MECKLENBURG COUNTY
Land Use & Environmental Services Agency

MEMORANDUM

To: Charlotte-Mecklenburg Planning Commission
From: Dylan J. Kirk, Mecklenburg County LUESA
Date: December 28, 2020 10:00AM
Subject: Initial Rezoning Petition Comments

2020-165: Taylor Davis

SCHEMATIC  
 SITE PLAN

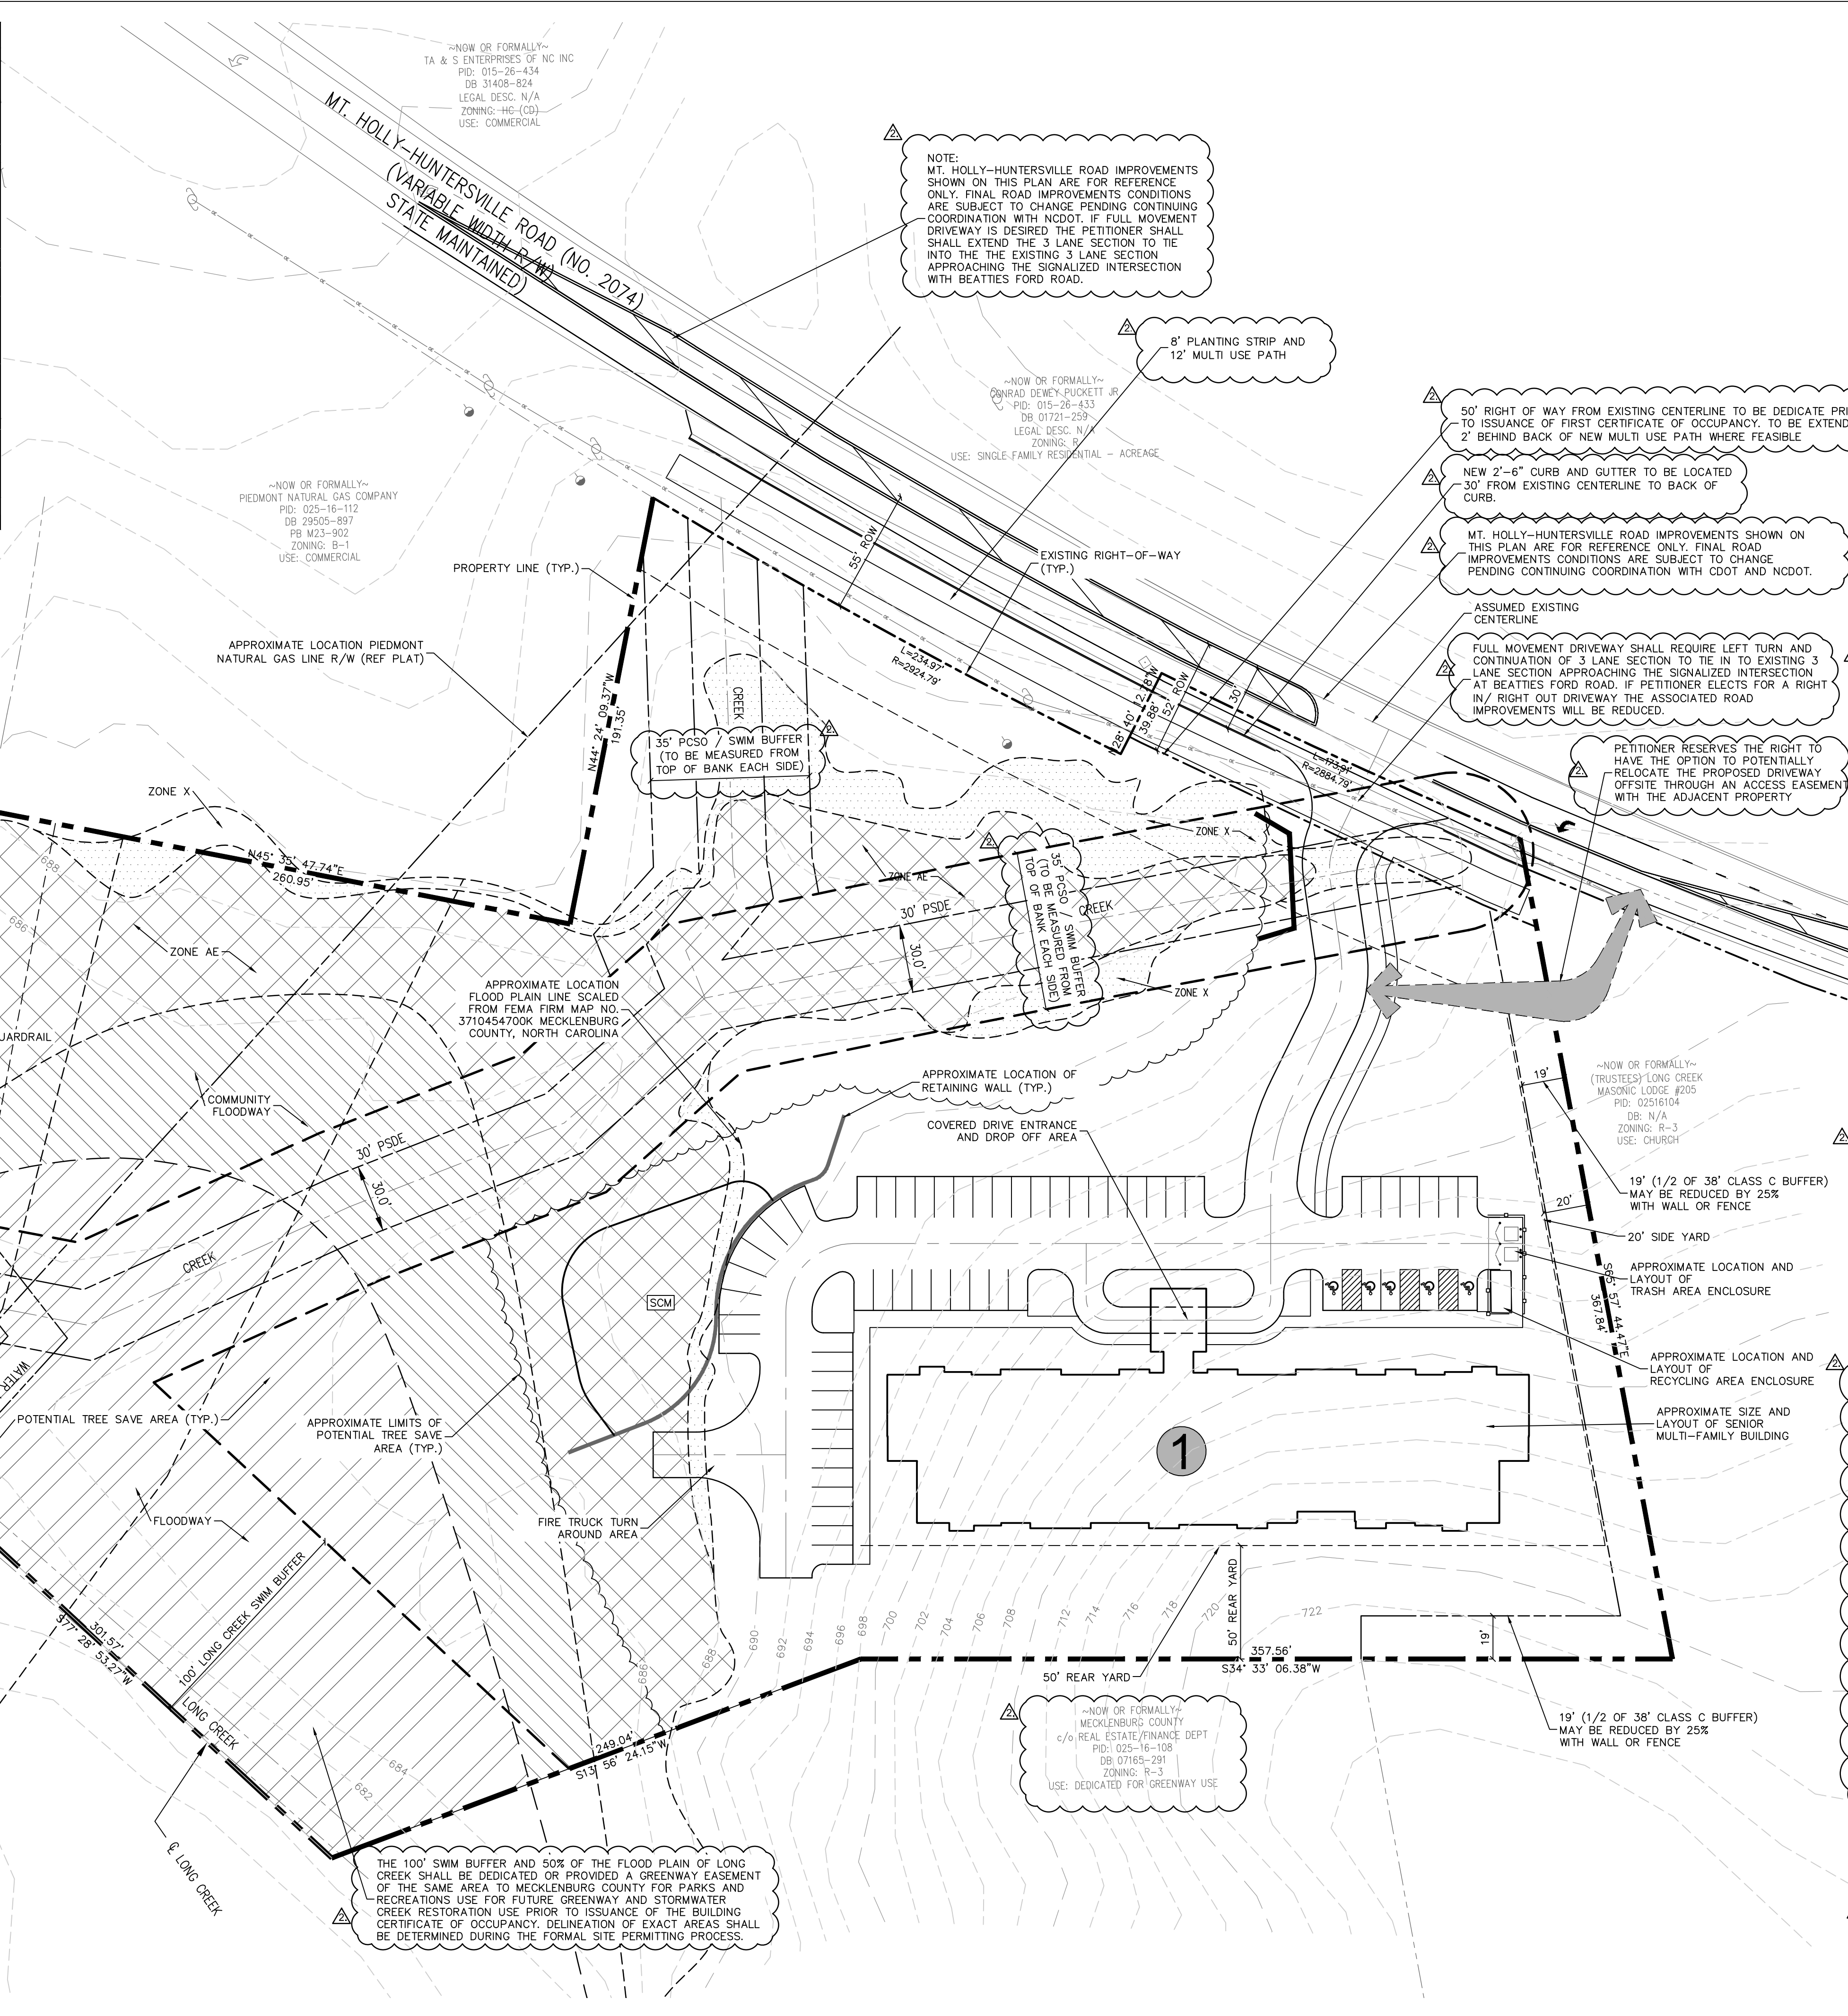
Storm Water Services Comments: A Floodplain Development permit must be obtained documenting compliance with the City of Charlotte Floodplain Regulations for all development occurring in the floodplain. In addition, staff recommend any structures proposed within the Community Special Flood Hazard Area be constructed to a Flood Protection Elevation equal to the Community Base Flood Elevation plus two (2) feet of freeboard based upon recent analyses of the future floodplains supported by the Storm Water Advisory Committee.
